**From:** alan.story@hertfordshire.gov.uk  
**Sent:** 25 July 2019 14:01  
**To:** Planning  
**Subject:** Planning application 6/2019/1411/MAJ - Plot 5100 Mosquito Way

**Response to Planning application from Hertfordshire County Council (T and CP GDP Order 2015)**

**District ref:** 6/2019/1411/MAJ  
**HCC ref:** WH/176/2019  
**HCC received:** 03/07/2019  
**Area manager:** Manjinder Sehmi  
**Case officer:** Alan Story

Erection of a multi-franchise car dealership (sui generis use) with offices (B1 use class), workshops (B2 use class) and car storage (B8 use class), together with car parking, cycle parking, boundary treatment, landscaping, lighting and access

Drawing Title
Workshop C and West Showroom
First Floor Plan
Upper Showroom and Secure Car Storage

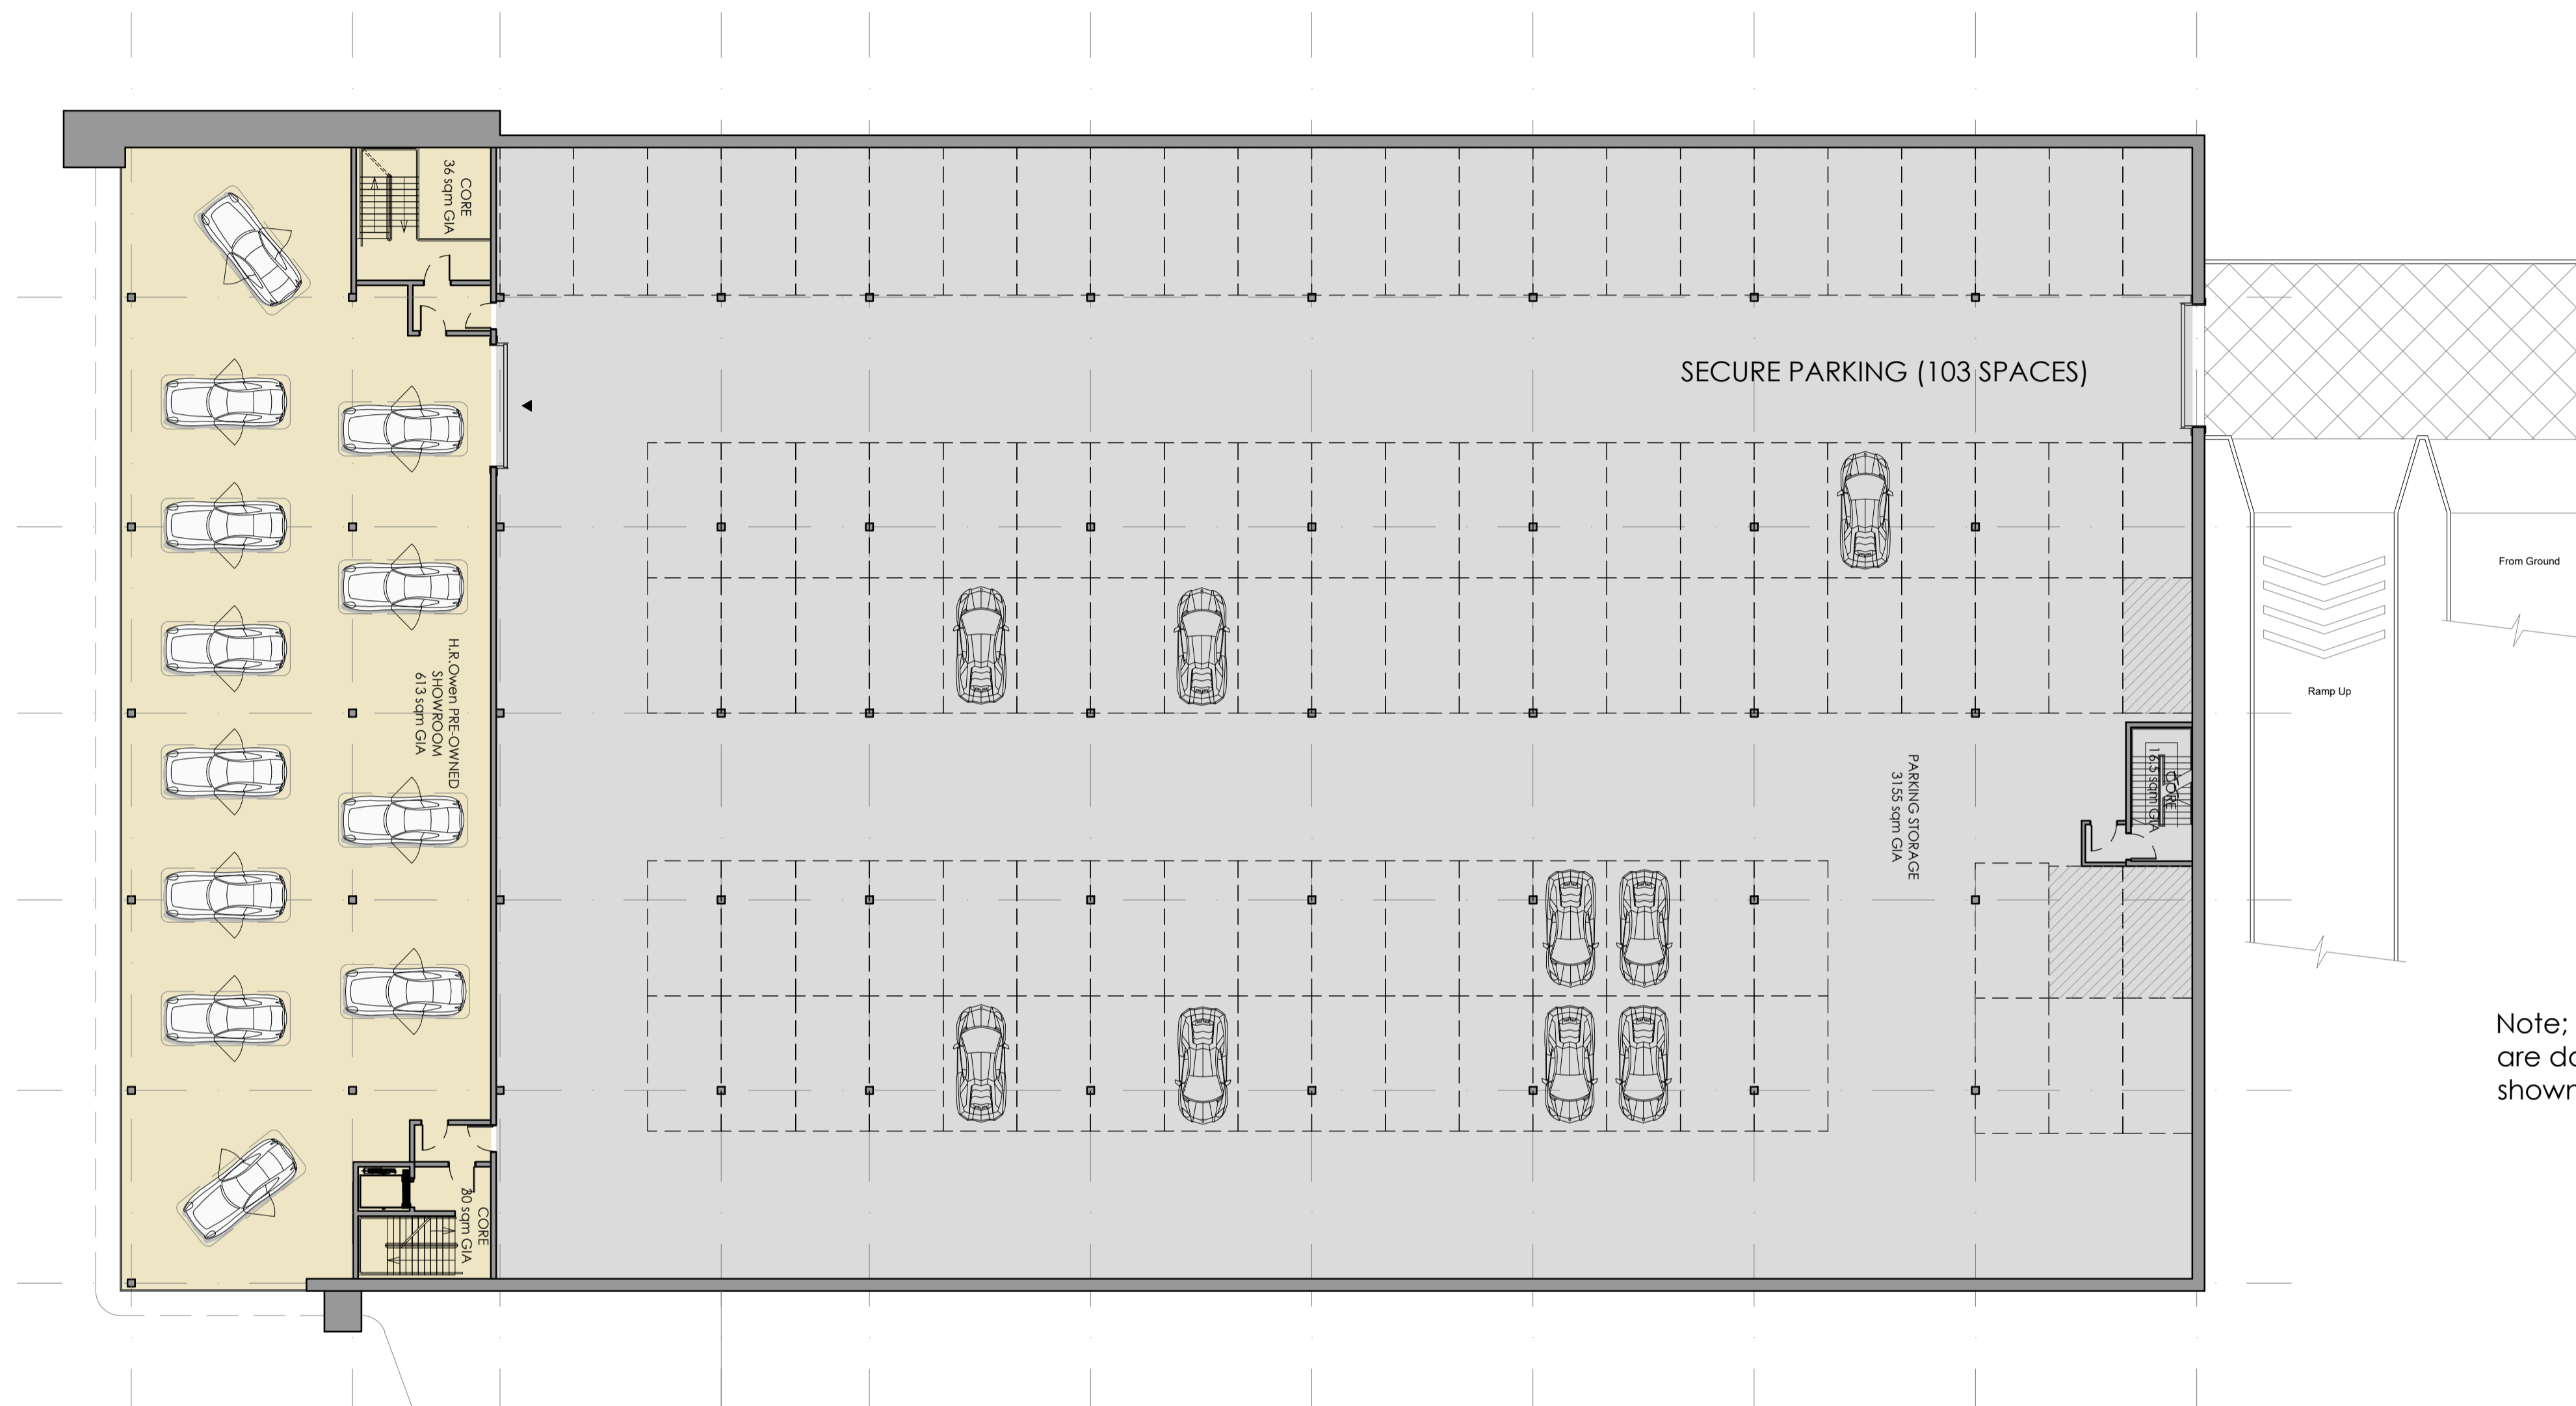
Much of this parking is provided as multistorey parking over workshop C and represents parking of vehicles for sale. Ramp structure to rear enables use of these spaces. The developer is directed to ensure that ramp structures are designed in a manner that complies with the IStructE recommendations on the design and construction of multistorey and underground car parks, paying particular regard to ramp gradients and transitions, and may need to consider the use of shallower transition ramps at the top / bottom of each ramp given the potential for low vehicle clearances given the specialist nature of the proposed occupier.
